Re: Appeal of Determination of Non-Significance  
Stampede Sand & Gravel, CU-09-00002

6/18/09 Determination of Non-Significance issued by the Kittitas County Community Development Services ("CDS") of the Stampede Sand & Gravel Application No. CU-09-00002 for a Conditional Use Permit for a temporary asphalt plant and concrete batch plant.

Re: Stampede Sand & Gravel Conditional Use Permit (CU 09-00002)

BOUNDARY & TOPOGRAPHY
 F2M, LLC, dba SNOQUALMIE
 EASTSIDE CONSULTANTS, INC.
 ENGINEERS - SURVEYORS

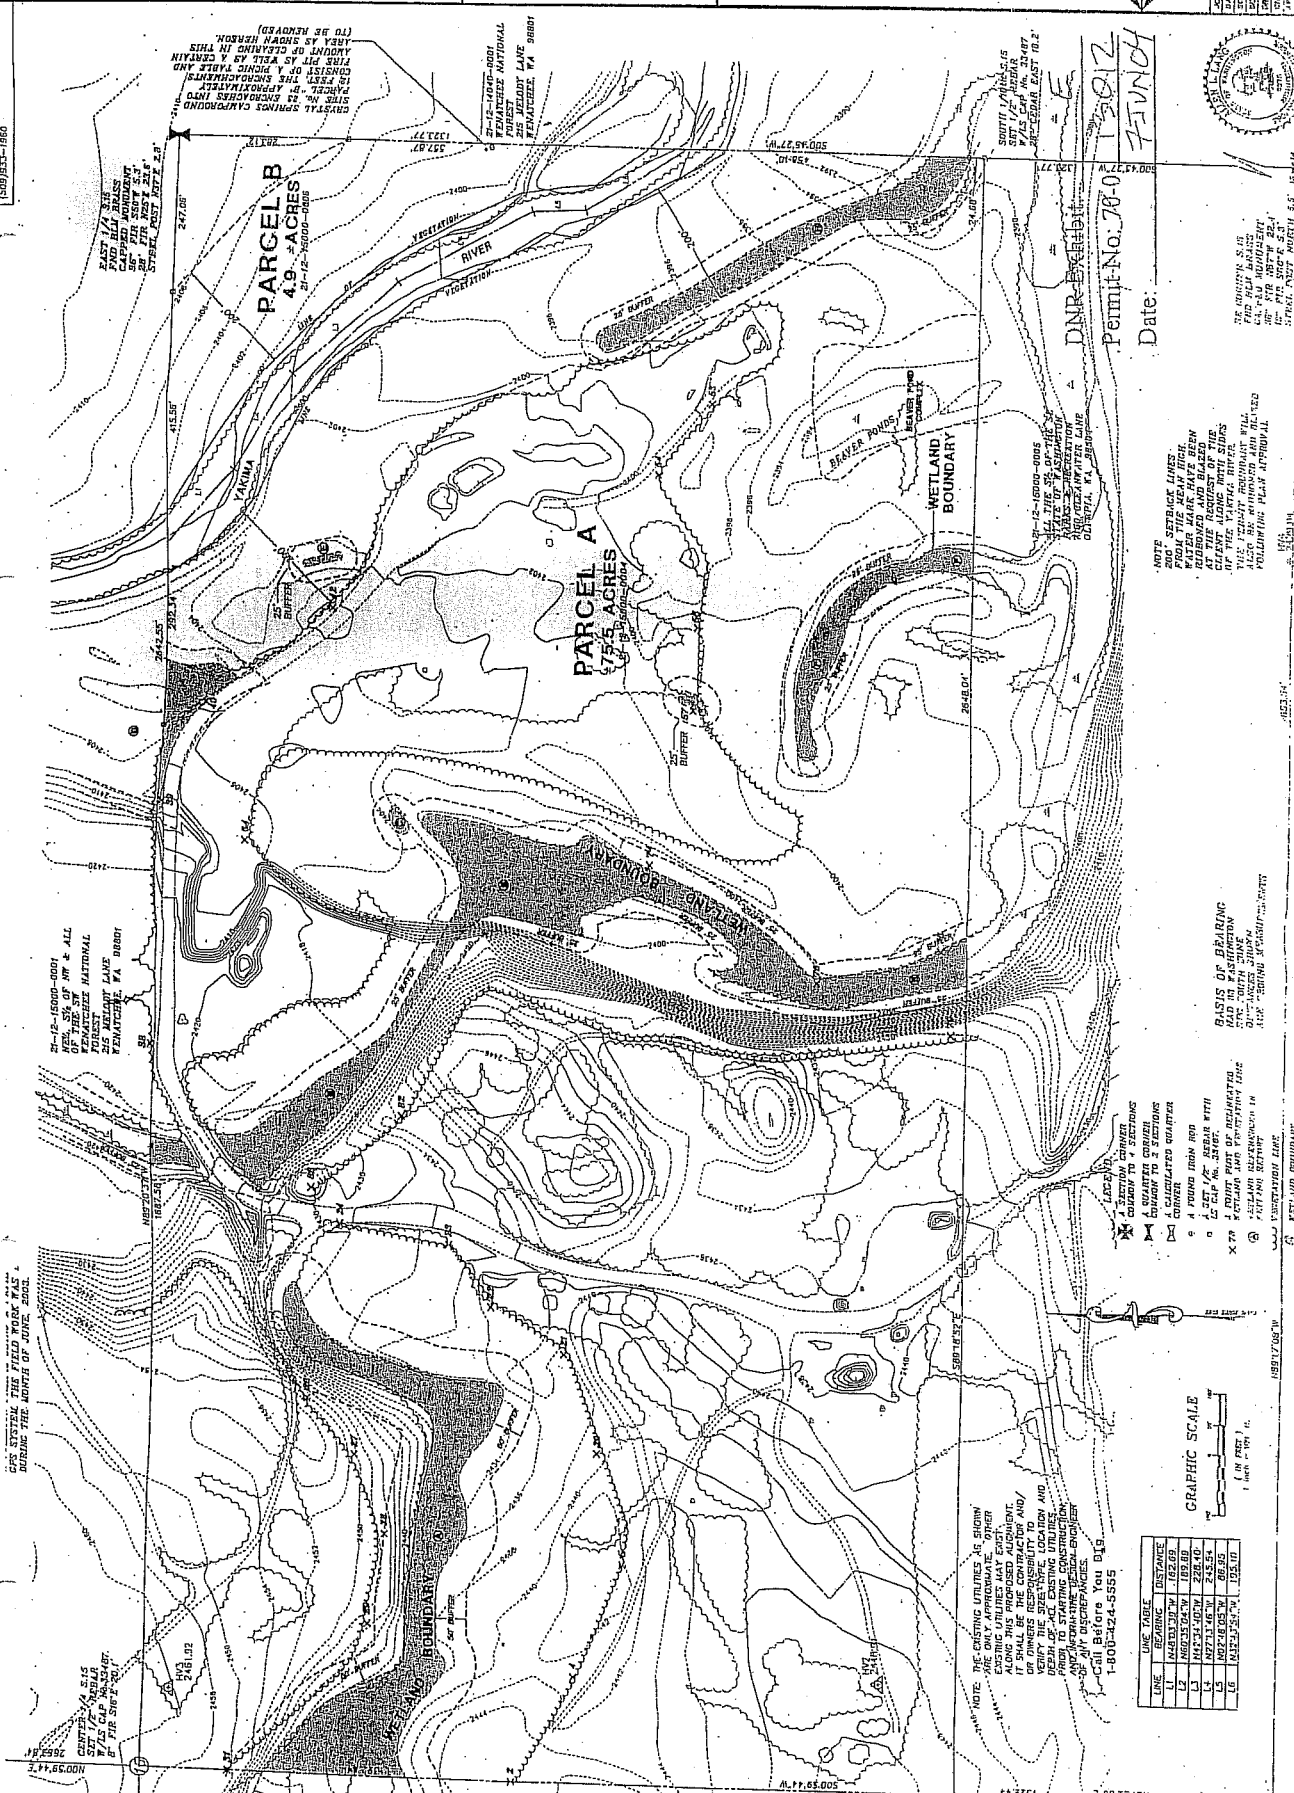
(6) A survey of the project site attached to Stampede's application (Exhibit "C" attached and incorporated herein) discloses the Yakima River provides the Northeast boundary of the property and the project site contains numerous and relatively extensive wetland areas. The proposed asphalt plant, concrete batch plant and diesel generator will require the use of substantially more petroleum products and chemicals than are presently used on the project site. The use and location of petroleum products and other chemicals in proximity to wetlands in the Yakima River creates a probable, significant, adverse impact on the wetlands and river from spills. The Environmental Checklist fails to disclose the location within the project site of either the asphalt plant or concrete batch plant or material storage areas so the relationship of those areas to the wetlands and the Yakima River cannot be determined. In addition, the Environ-

1c. The EC indicates only sand and gravel are located on the site. The site obviously contains overburden which must be described by soil type and depth. The east portion of the parcel contains, or is adjacent to, the Yakima River. There may be wetland type soils associated with the creek which must be identified and fully delineated.

4a. The Yakima River flows adjacent to, and through, the eastern part of the project site. The EC indicates there are wet soil plants on the site and wetlands which must be protected. If wetlands are to be in any manner impacted, appropriate permits must be obtained from the Army Corps of Engineers.
